THE RESERVE AT  
CORRAL BLUFFS SUBDIVISION  
FILING NO. 2  
Construction Drawings  
El Paso County, Colorado

PCD File No. SF-18-010

**C1**

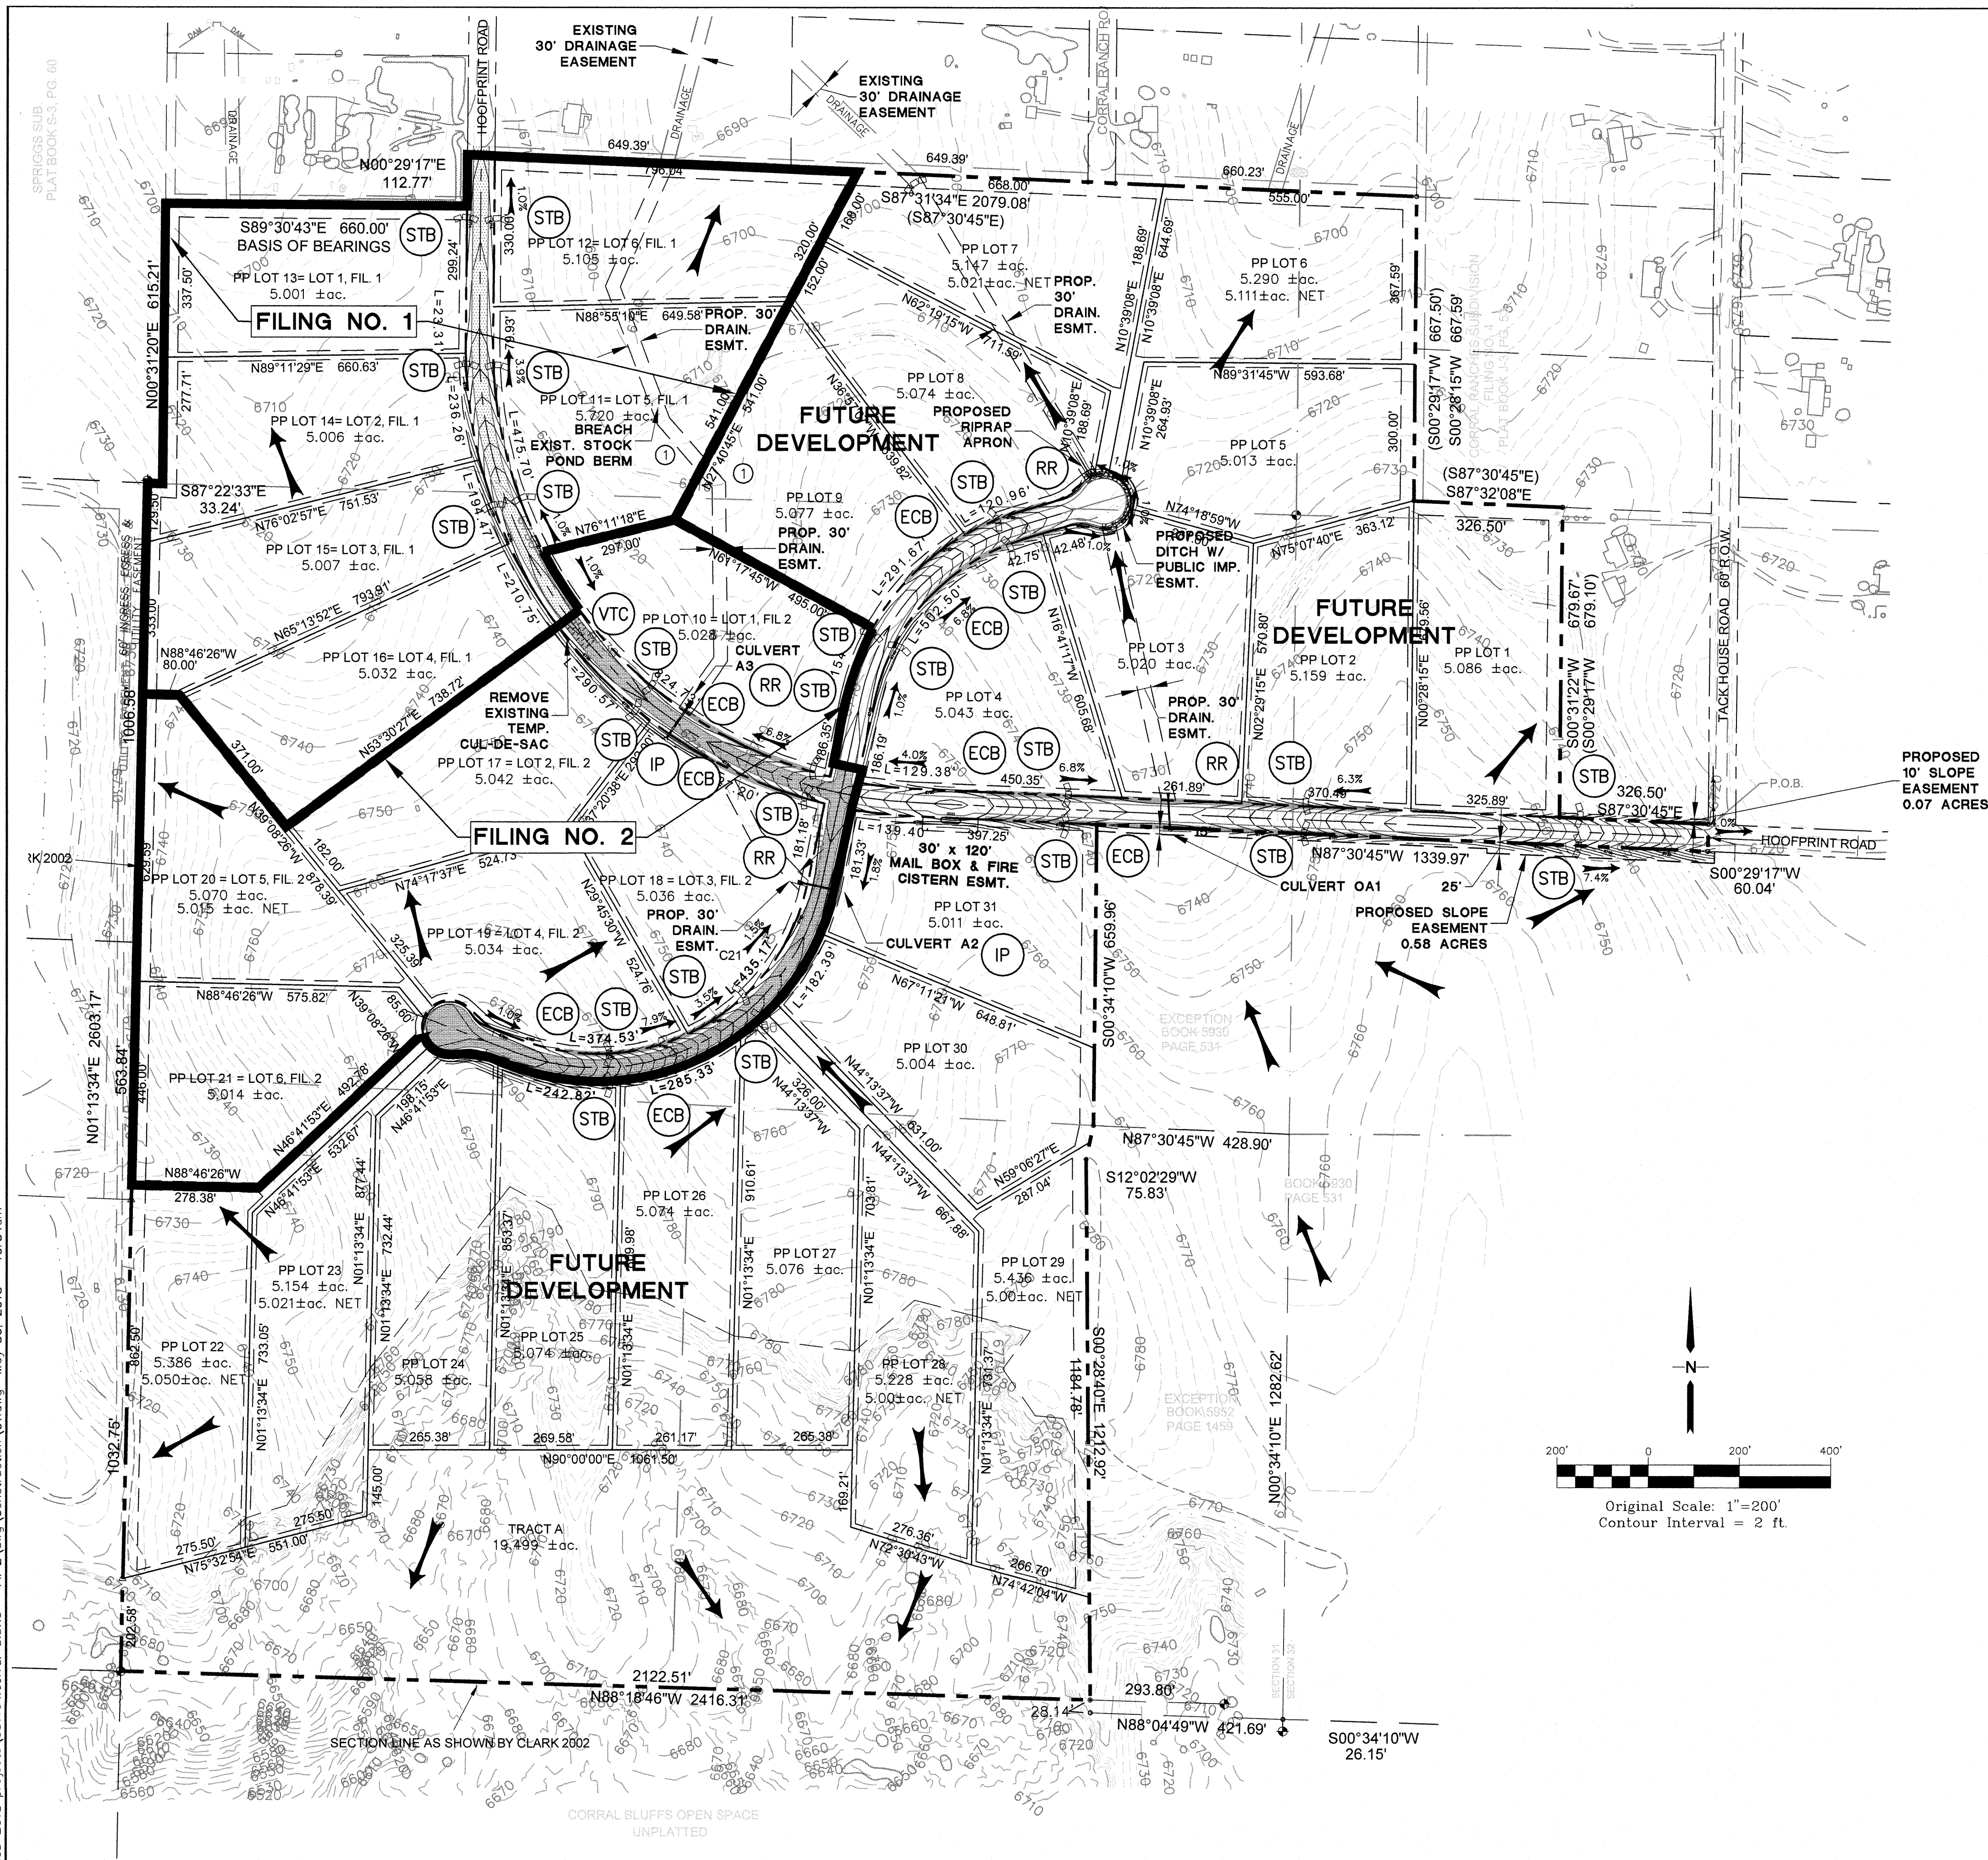
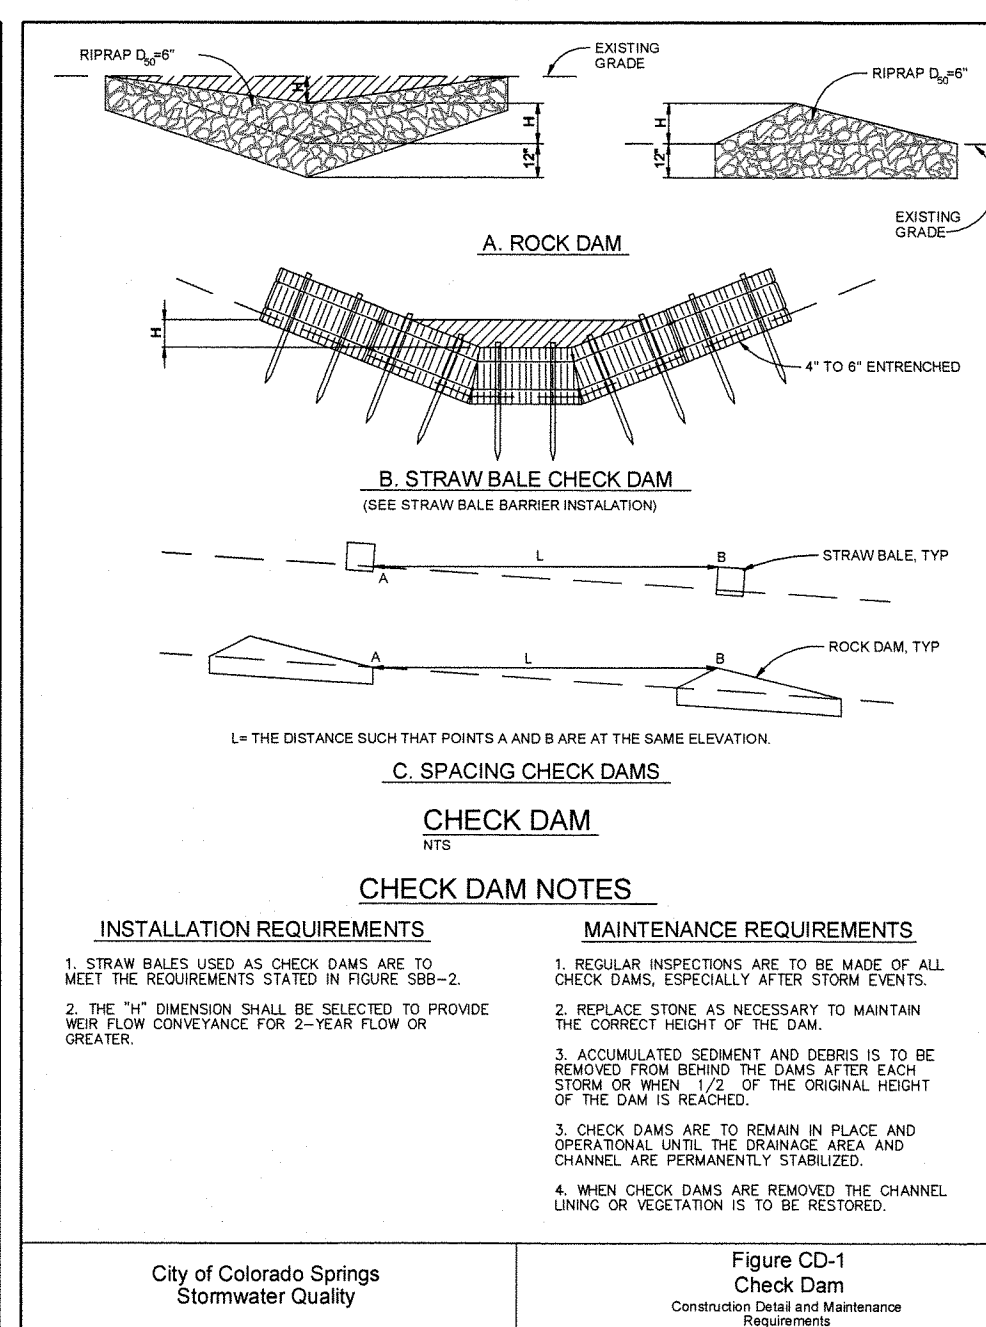
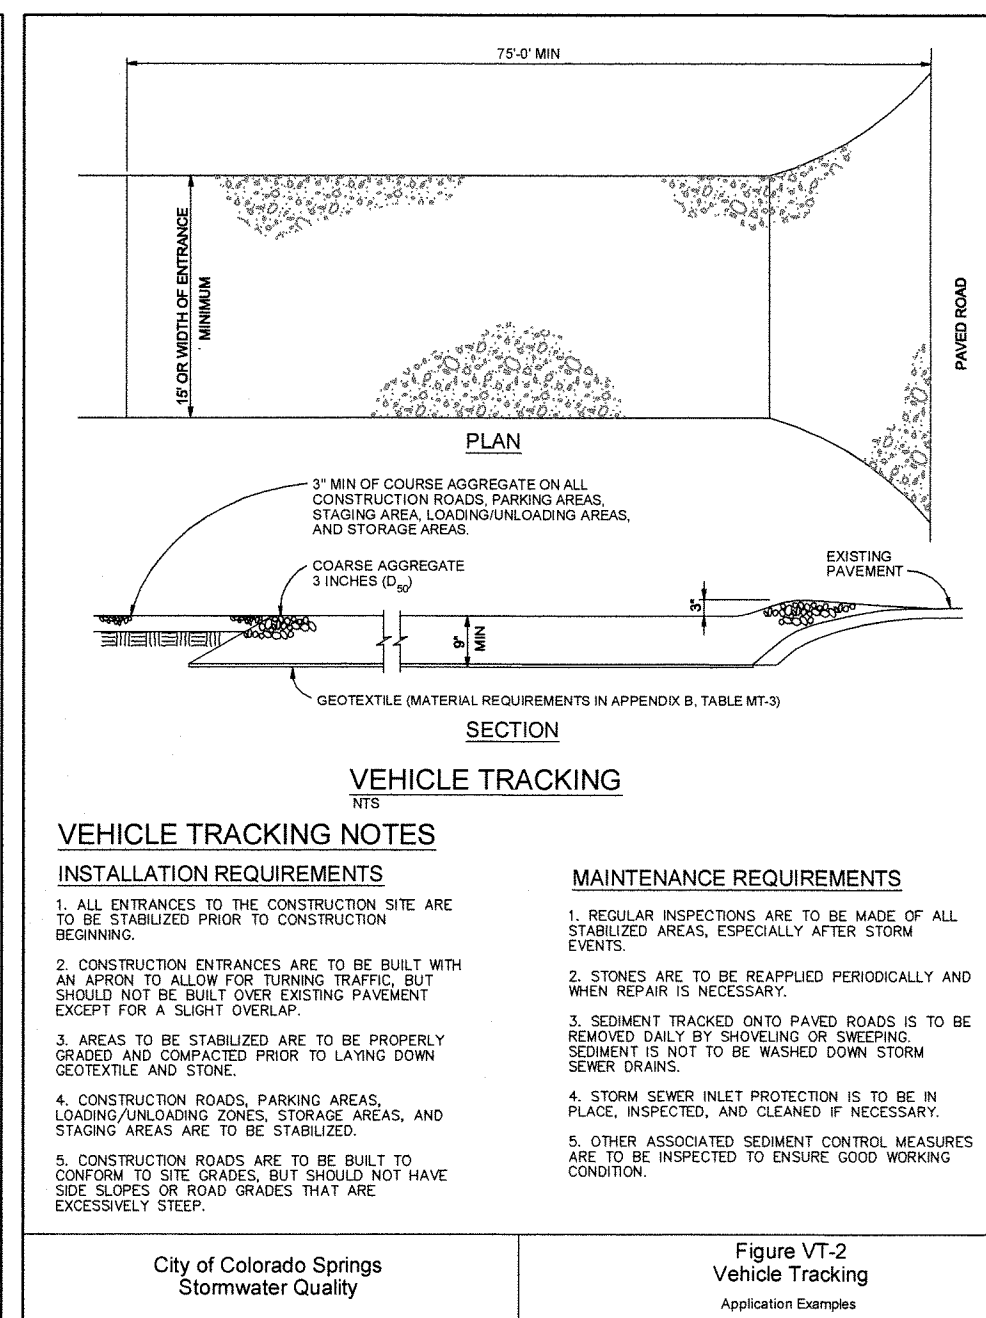
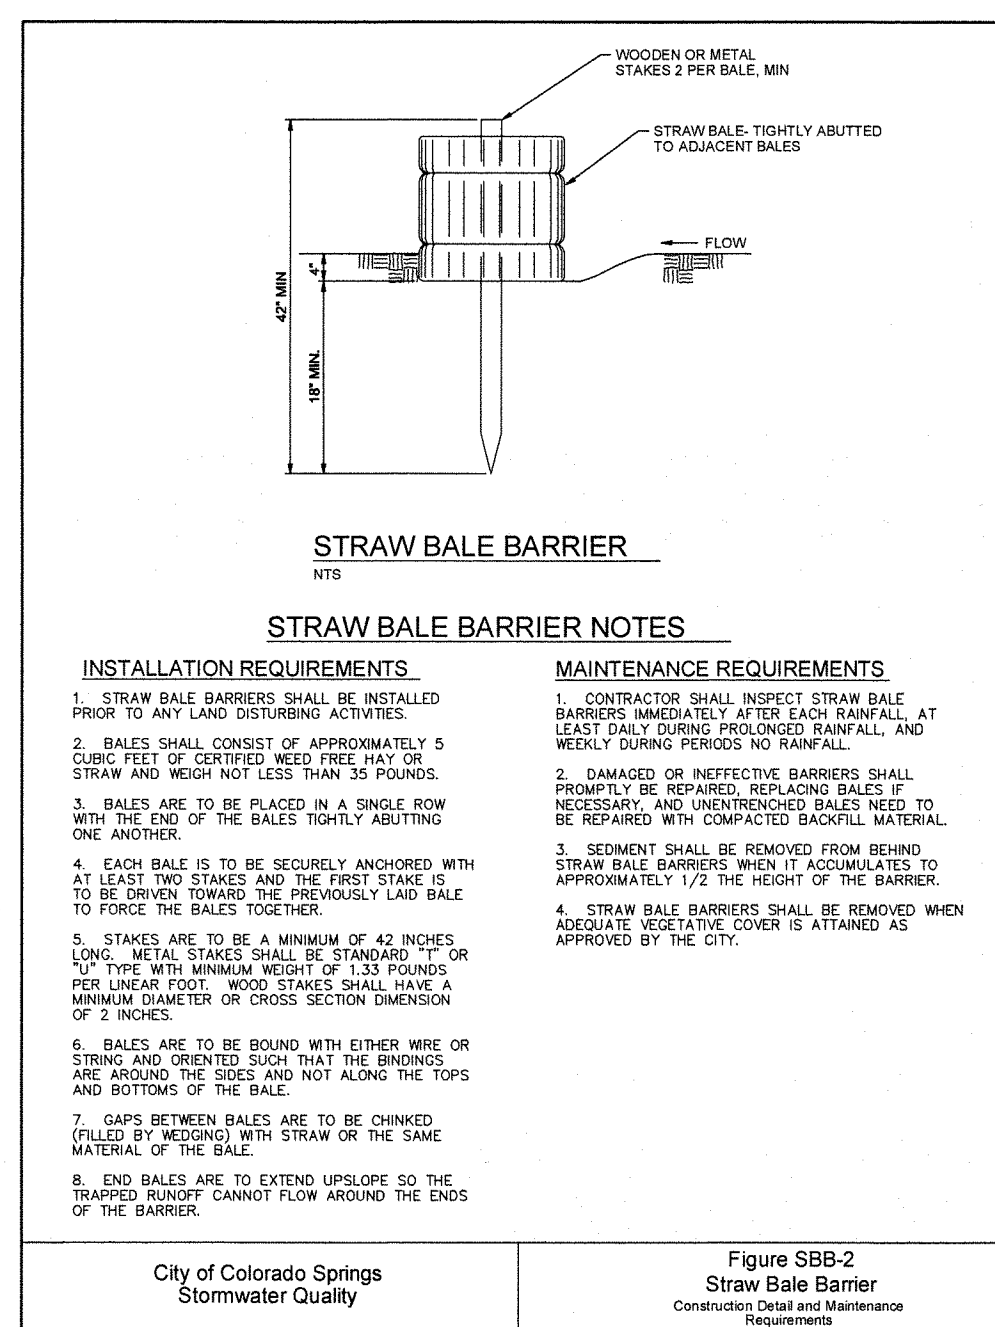
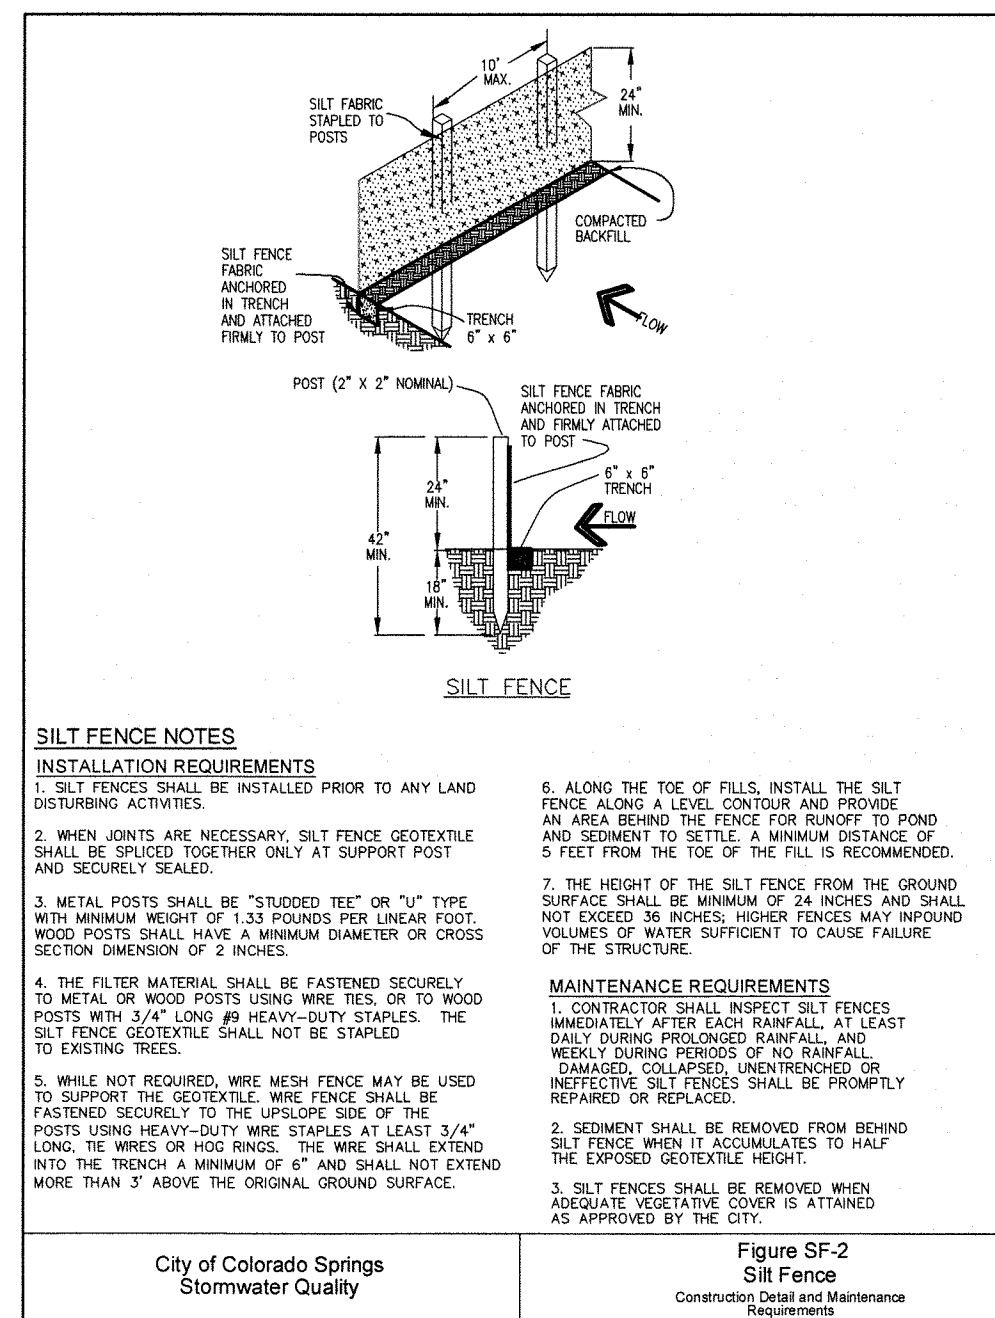
Sheet C1 and C2 are missing from the Construction Drawings Plan Set. Include with the re-submittal.

Review 1 comments to the GEC sheets (C1 & C2) are resolved.
